CITY OF ALBUQUERQUE

July 28, 2021

Re: El Parador Multi-Family Development
201 Yale Blvd SE
Traffic Circulation Layout
Architect's Stamp 07-22-2021 (K15-D107)

TRAFFIC CIRCULATION LAYOUT  
APPROVED

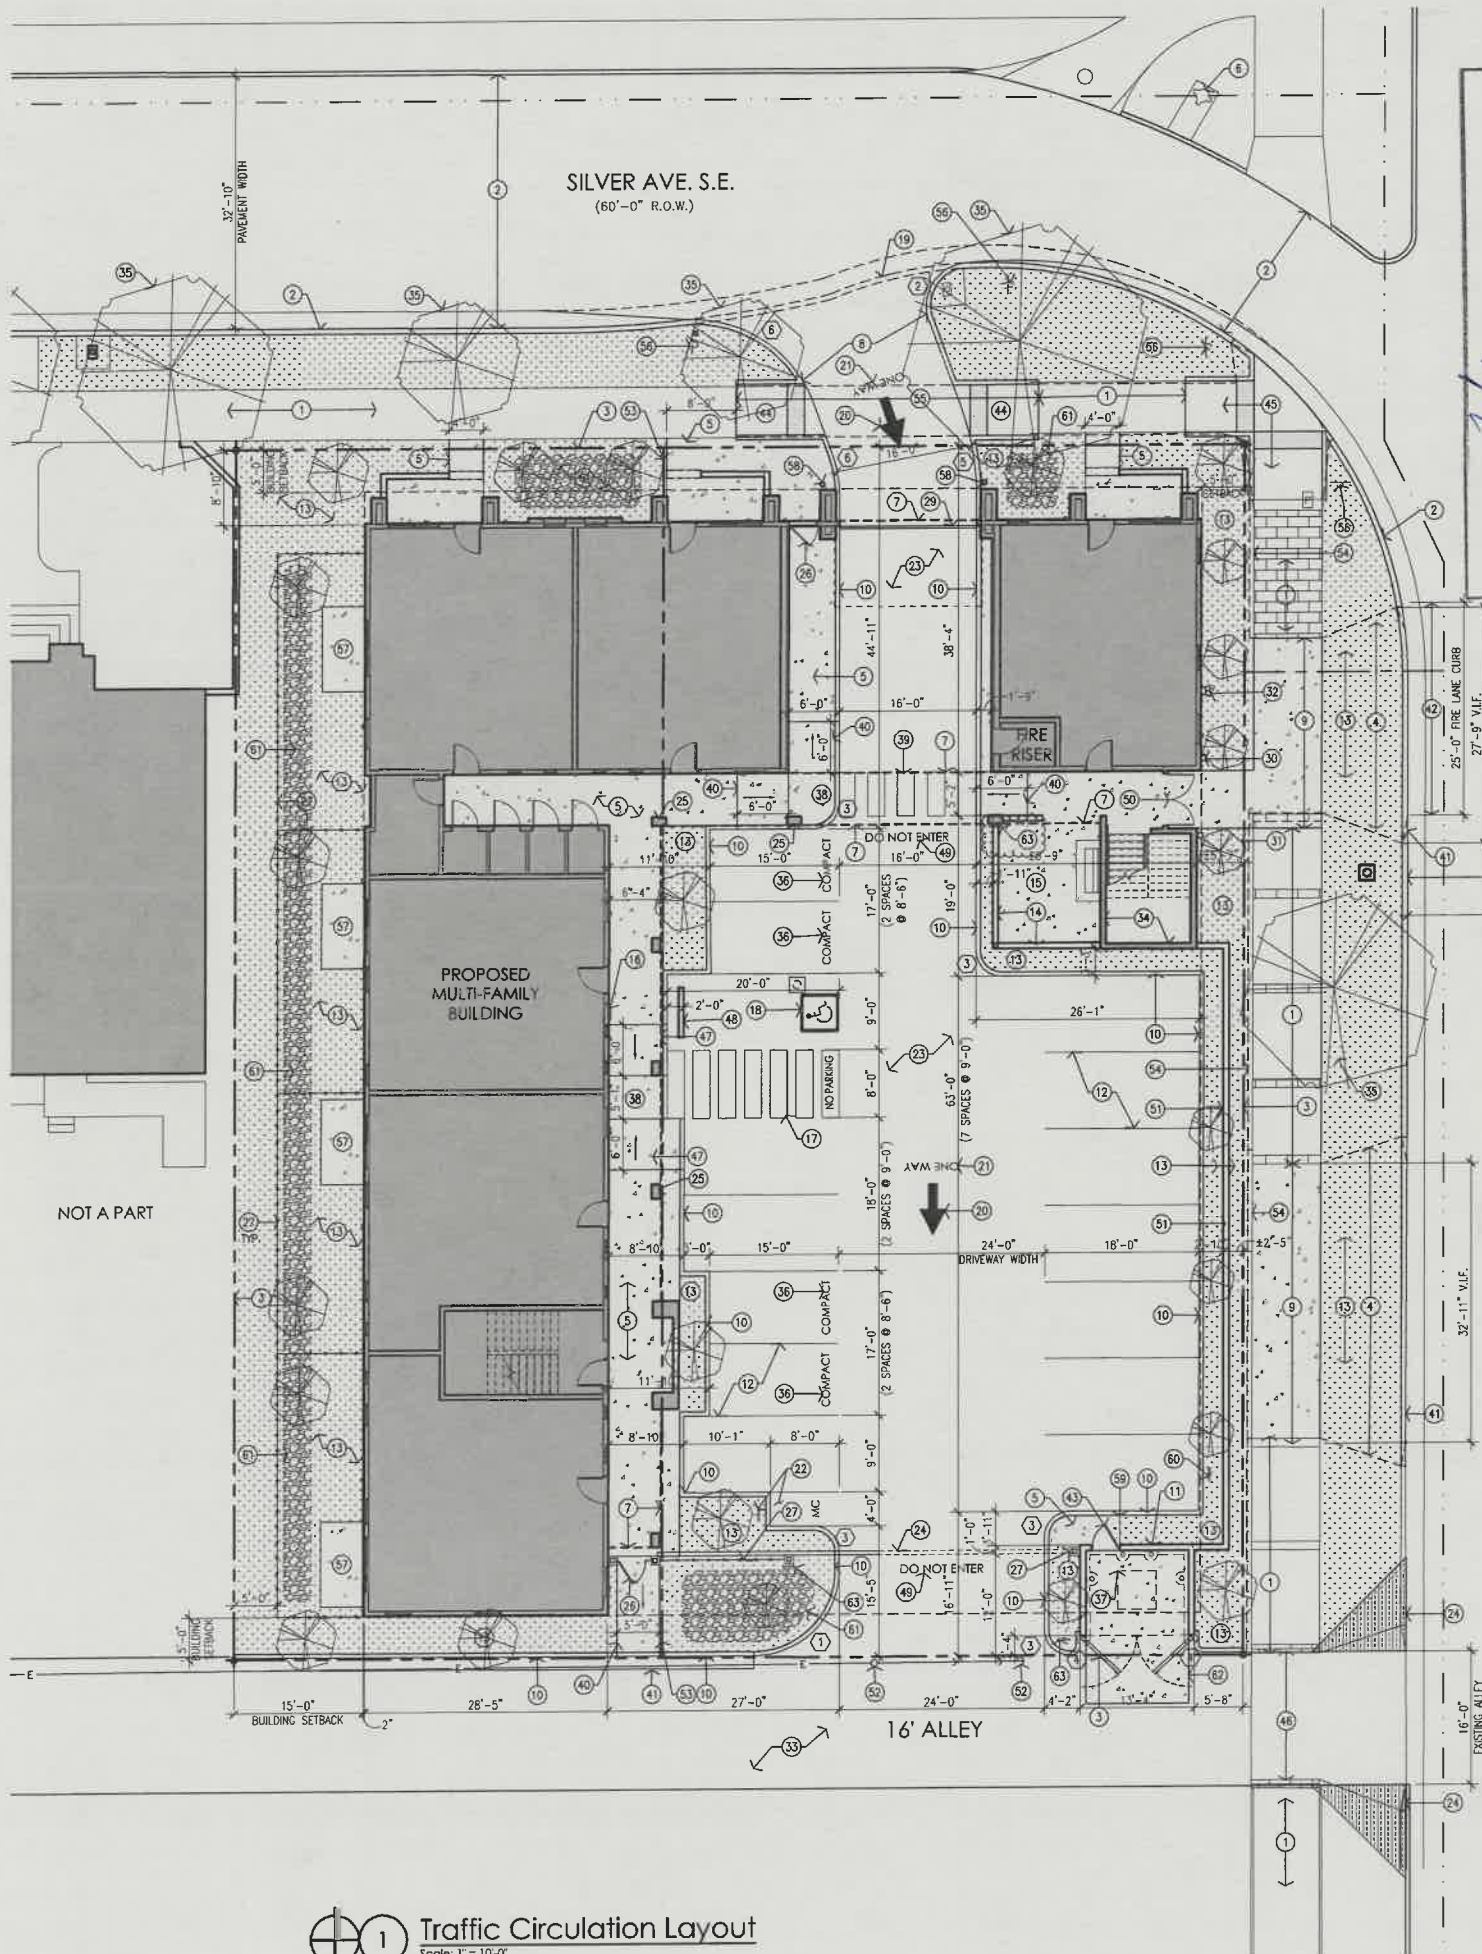
2. The proposed driveway off Silver Ave is too close to Yale Blvd and **will not be accepted**. Please **adjust site plan**. **Yale is classified as a Minor Arterial per DPM the location of the driveway should be 200 ft from Yale Ave.**

3. **Alley way/Yale proposed modified entrance:** You will need to provide construction notes/details for the entrance modification. **Details will be needed for valley gutter transition from 6 ft valley gutter transitioning into a alley gutter.**

4. **Keyed Note 5 (Silver Ave. entrance):** The arrow is pointed at proposed curb and gutter. Please adjust.
5. **Keyed Note 20 & 21:** Pavement marking details will be needed at entrance and end of entrance will need another pavement marking which states **Do Not Enter. This needs to be located at end of throat depth of entrance into parking lot and at end of parking lot (adjacent/end to proposed gate)**

6. **Keyed Note 25:** You are showing proposed sidewalk adjacent to proposed ADA ramp slope and transitions. This situation is a **tripping hazard for ADA pedestrians**. Please clarify this safety concern.

7. **Keyed Note 26:** Pedestrian access gate needs to be 6 ft in width per ADA pedestrian pathway requirements (Silver Ave entrance driveway).
8. **Keyed Note 38:** This read 2% max. slope on landing.

9. **Keyed Note 39:** Provide the color of striping for proposed cross walk pavement markings.
10. **Keyed Note 42:** Specify the color of Paint for Fire Lane.

11. **Keyed Note 44:**

- **Call out COA std dwg 2442 instead of 2441** for this type of unidirectional ramp.
- Silver Ave: All portions of proposed ADA ramp **SHALL be located within public ROW.**

12. **Keyed Note 46:** Provide the alley pavement design.
13. Identify all existing access easements.
14. Identify the right of way width, medians, curb cuts, and **street widths** on Silver Ave. and Yale Blvd.

15. **ADA curb ramps must be updated to current standards and have truncated domes installed located within public ROW. This includes keyed note 45.**
16. **All existing driveways/pad must be updated/current ADA standards.**

17. **Motorcycle parking space:** Label pavement MC.
18. All bicycle racks shall be designed according to the following guidelines:
 - a. The rack shall be a minimum 30 inches tall and 18 inches wide.

23. List radii for all curves shown; for passenger vehicles. Radius for delivery trucks, fire trucks, etc. **is 25 ft. or larger.**
24. Per the IDO, a **6 ft. wide** **ADA accessible pedestrian pathway is required from the public sidewalk to the building entrances.** Please clearly show this pathway and provide details.

25. Refuse vehicle maneuvering shall be contained on-site. The refuse vehicle **shall not back into the public right of way.** Provide a copy of refuse approval.

26. All one-way drives shall have "One Way" and "Do Not Enter" signage and pavement markings. Please show detail and location of posted signs and striping.
